Town & Country Planning Act 1990 (as amended) s211 Notice
Application for Prior Notification of Work to Tree(s) in a Conservation Area

Development Works to 1 x Sycamore Common/Acer (T1) - this is a tree in a conservation area which is an old pollard and requires a 30-40% crown and radial reduction to help the tree continue in it's maturity for future stature and remove any dead wood as required.

Location 1 Flat 1 Selborne Place Selborne Road LITTLEHAMPTON

AGURT / RIGULI TREE SURGERY - Ref: T1. located at Back Gravel

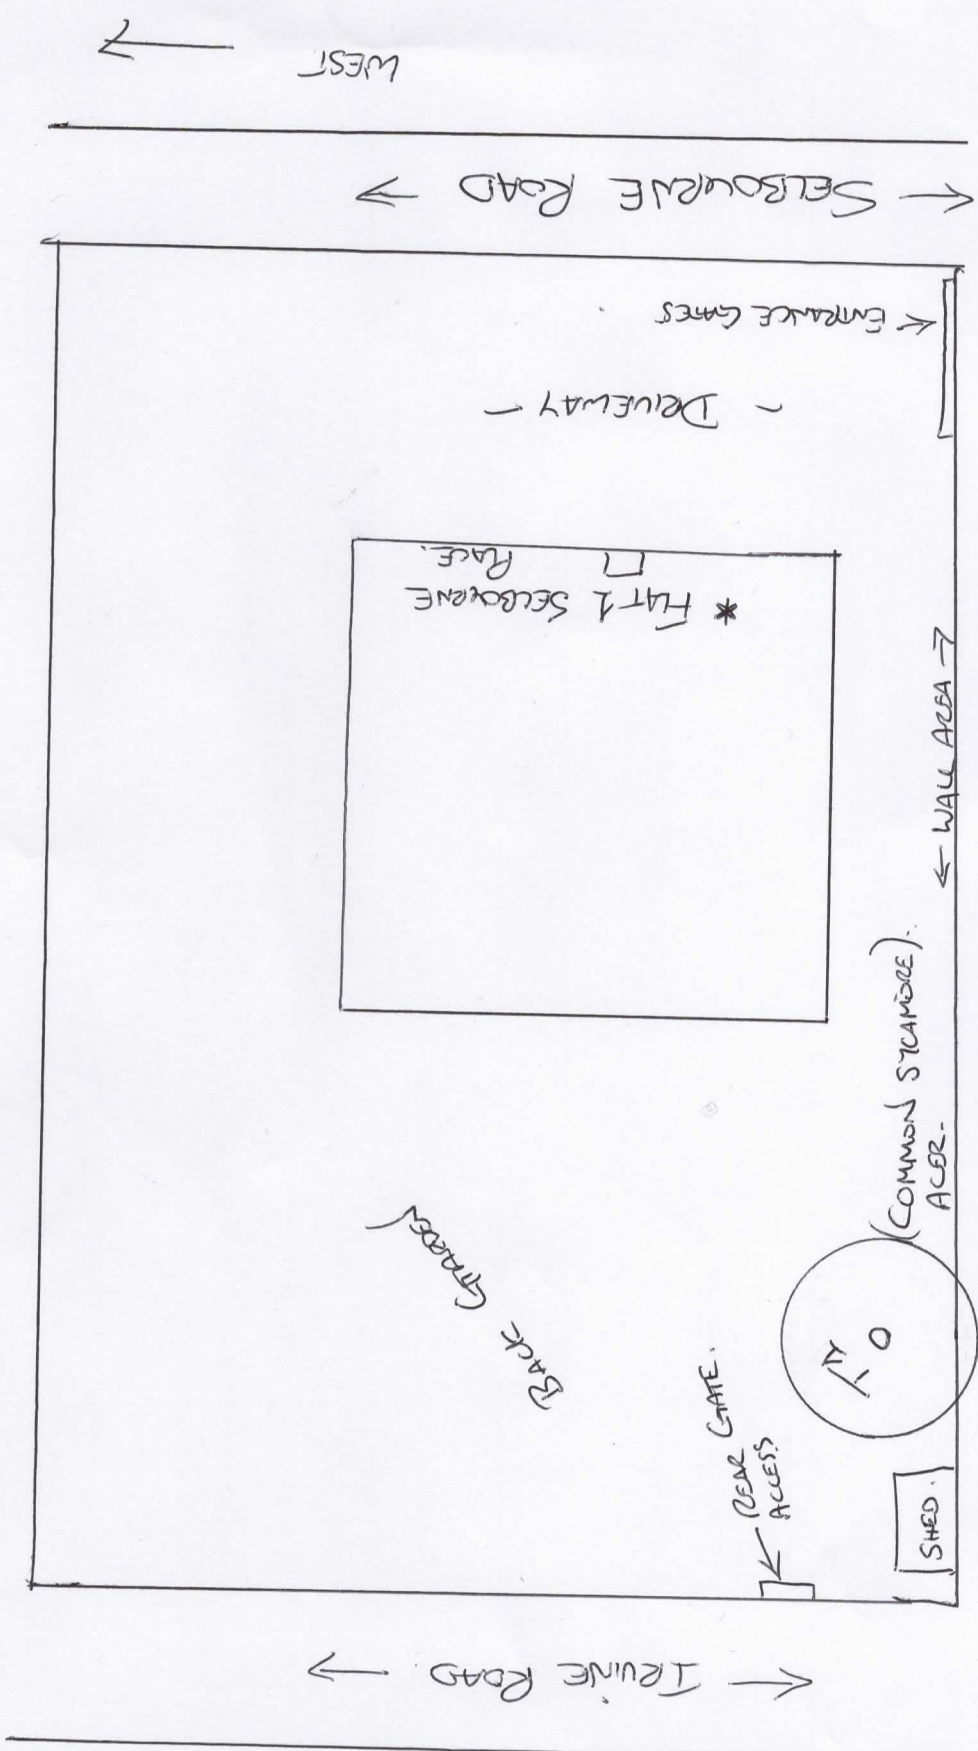
Please provide all crown reduction measurements in metres.
